4 Hill Street Permit # 2017-01308

I am currently reviewing your project for verification of compliance with the State of Maine and City of Portland Fire and Life Safety NFPA Codes and need the following information to complete my review:

2nd Floor

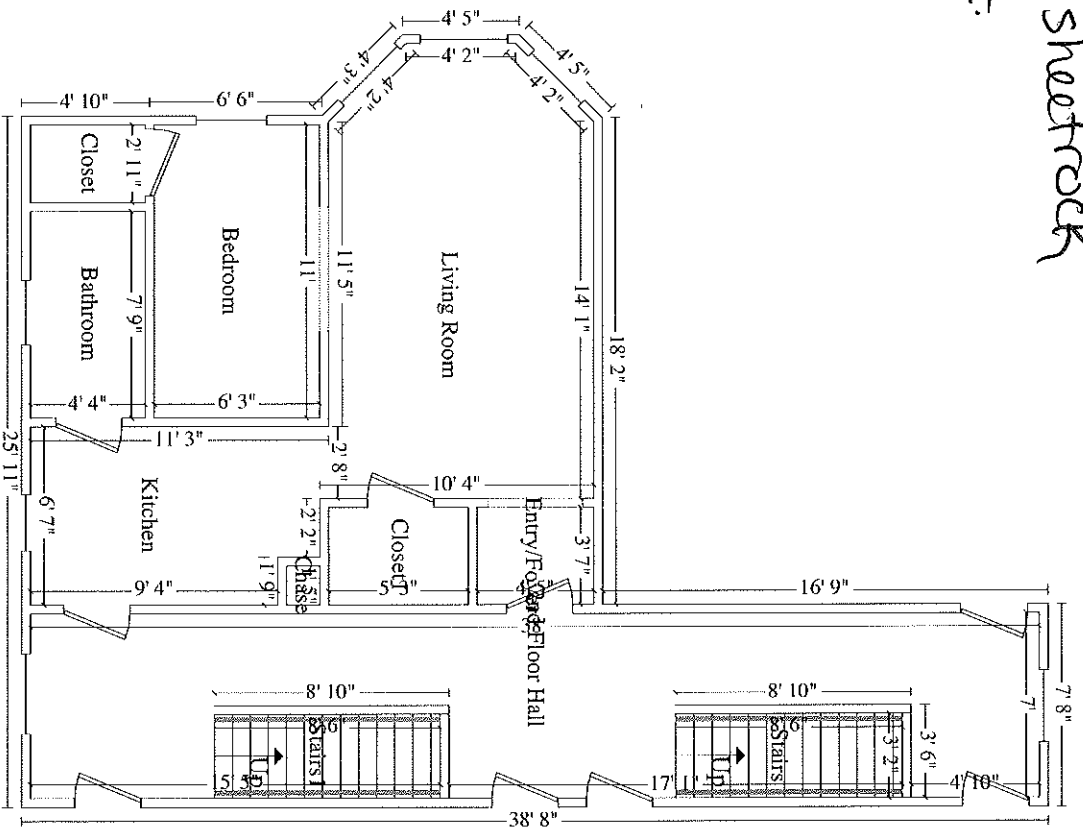
1. Are any of the wall locations changing or are you just changing the sheetrock? If so provide existing and proposed plans.
2. Is any of the sheetrock on either side of the walls for the hall / stair enclosure being replaced? If so please show where the sheet rock is being replaced and what the fire separation rating of that wall will be.
3. I any the the ceiling being replaces? If so please show where the ceiling is being replaced and what the new ceiling will be made of.
4. Are any of the door being replaced. If so please show on a plan which doors will be replaced and what the fire separation rating of the new doors will be.
5. Please provide a key plan the second floor so we can tell were the work is being done.

Hi Jason,
We are not changing any walls; no sheetrock on either side of the hallway is being replaced; we are replacing ceiling with 1/2 inch sheetrock; we've decided not to replace fire doors to the hallway. They are rated 90 minute metal doors.
I am dropping off a very amateur schematic of the second floor to you in person.
Sincerely,
